From: Gregg, Robert <Robert.Gregg@lancashire.gov.uk>
Sent: 25 January 2019 11:55
To: Adam Birkett
Cc: planning; LHS Customer Service
Subject: APP. 3/2018/1180 - SPEED PARLOUR, CHATBURN ROAD, CLITHEROE

Change of use from sui generis to A5 (hot food takeaway) Asian street food deli. Proposed hours of business 8am to 6pm Monday to Friday, 10am to 4pm on Saturdays, closed on Sundays. Resubmission of planning application 3/2018/0432.

Drawing Title
PROPOSED PLANS & ELEVATIONS

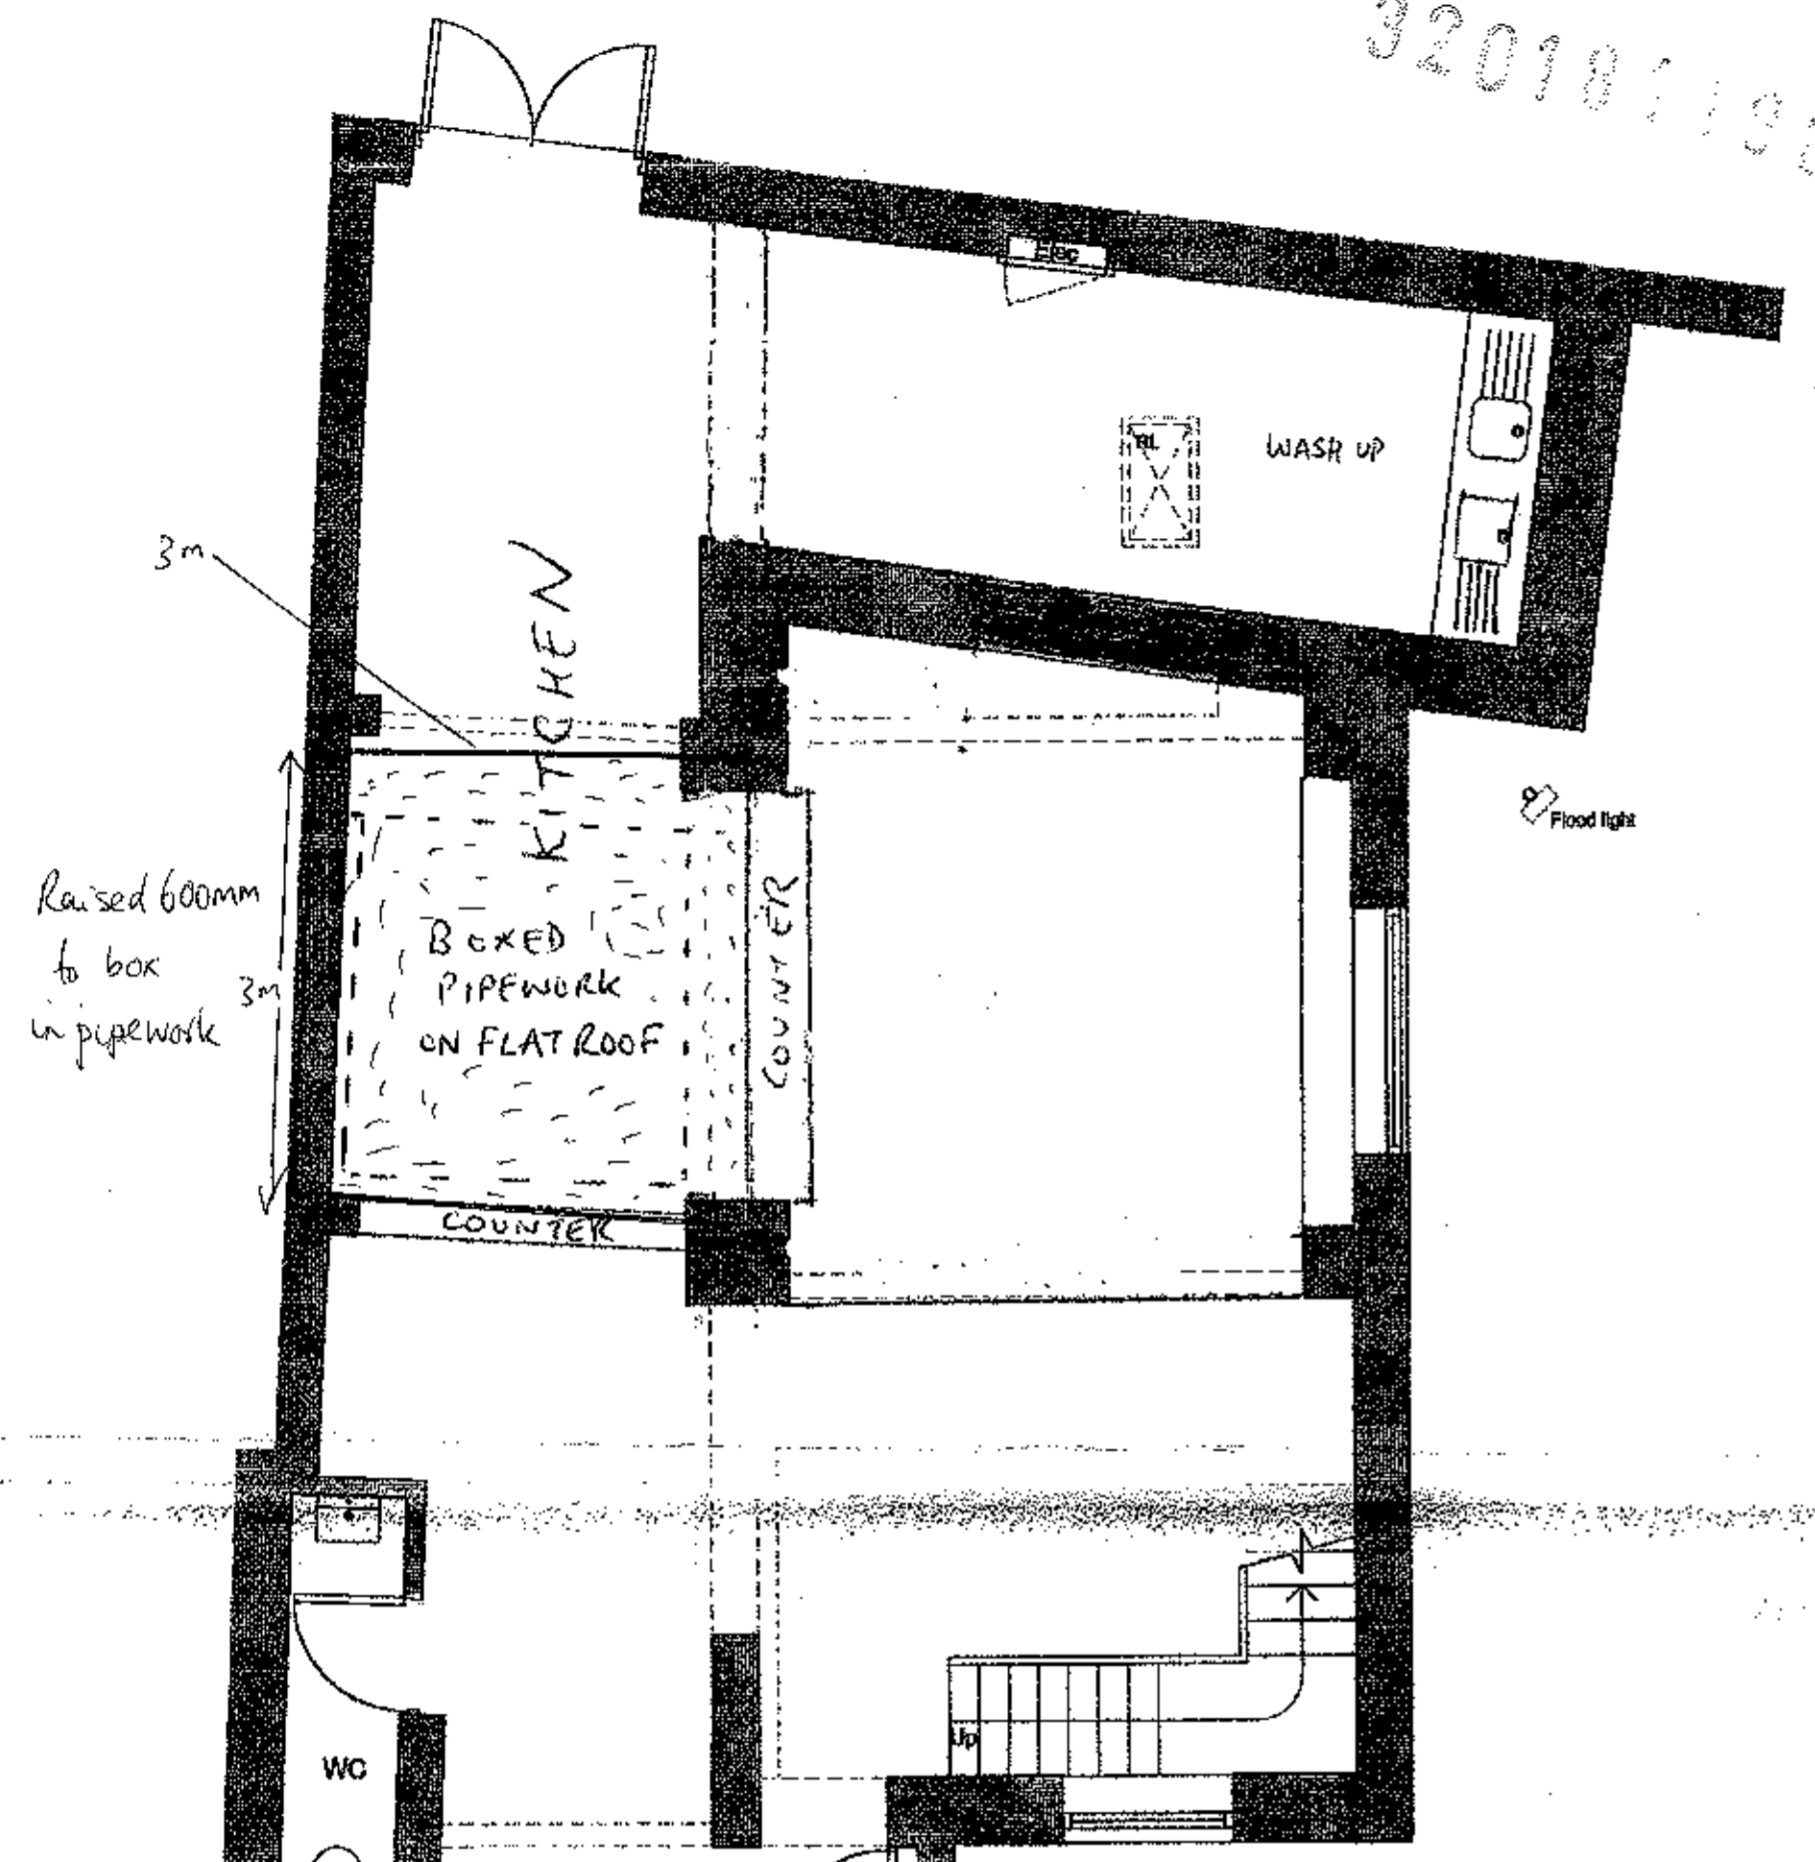
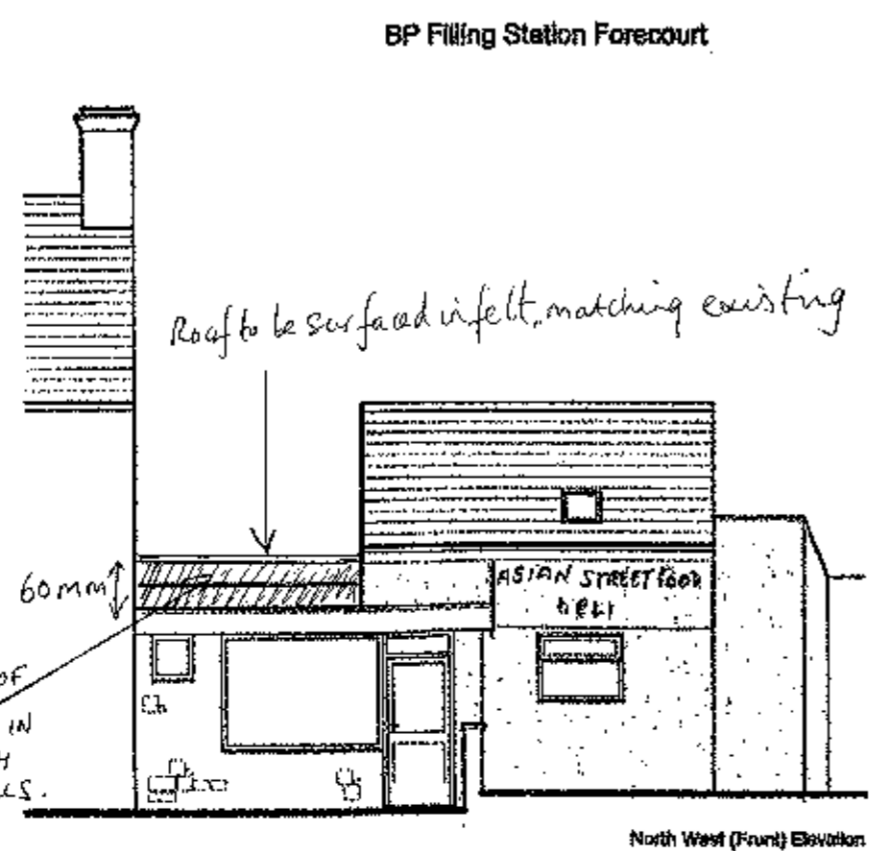
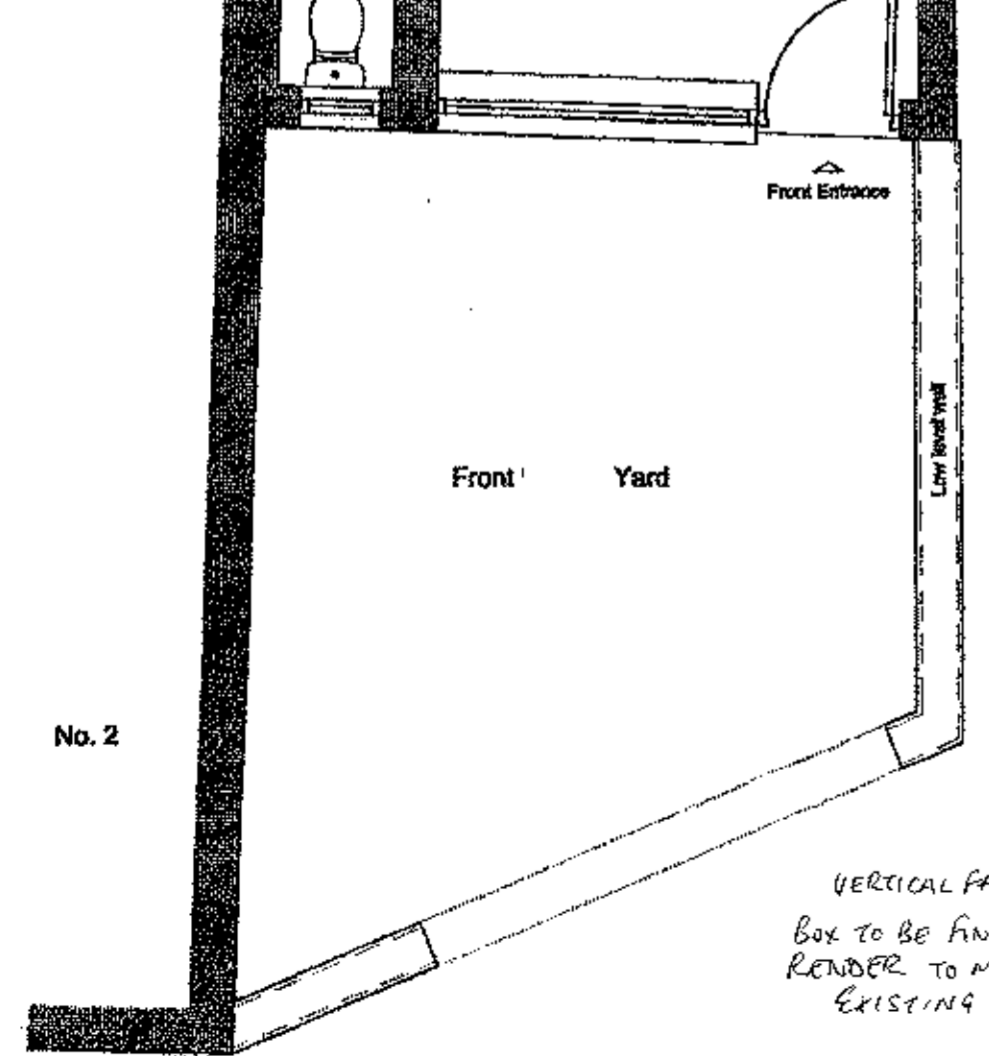
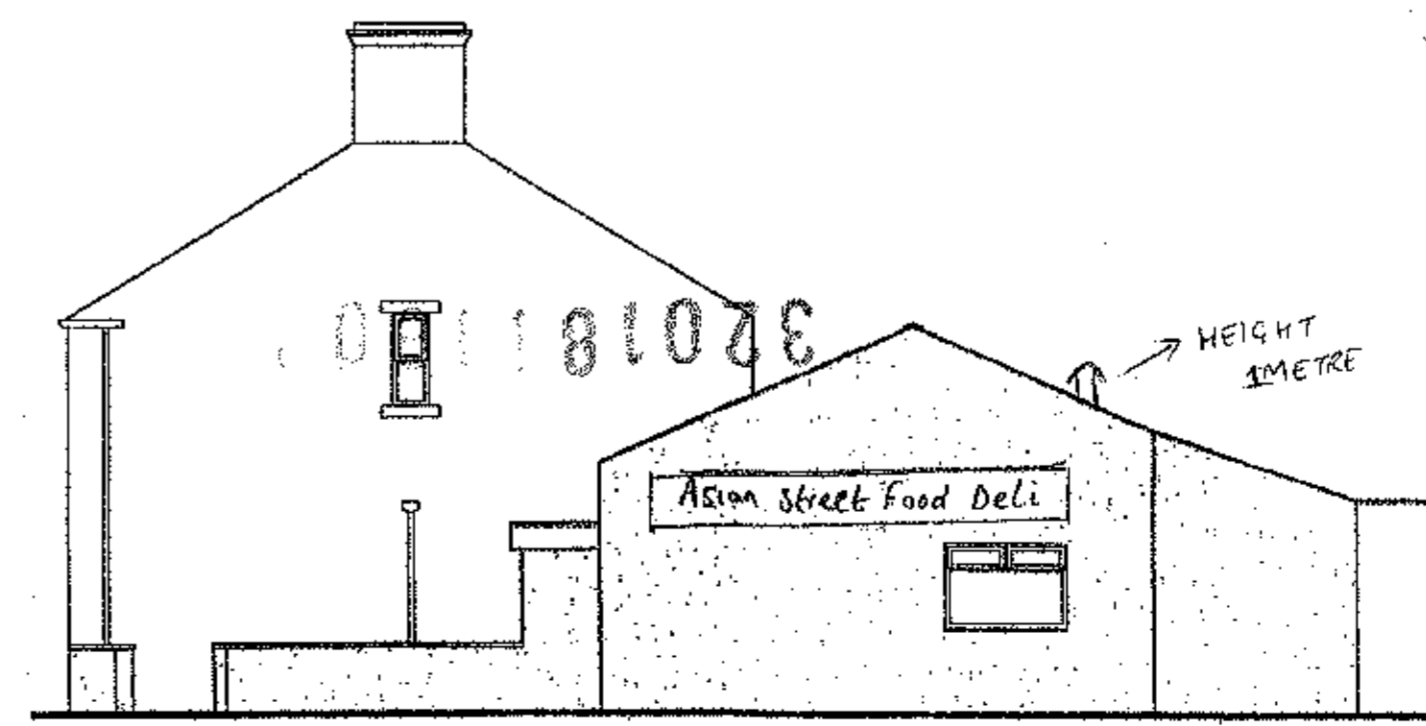
It should be noted that the forecourt at the front of the shop may be used as external seating, any such provision including any waste bins should be confined to the shop curtilage and not impede the garage forecourt.
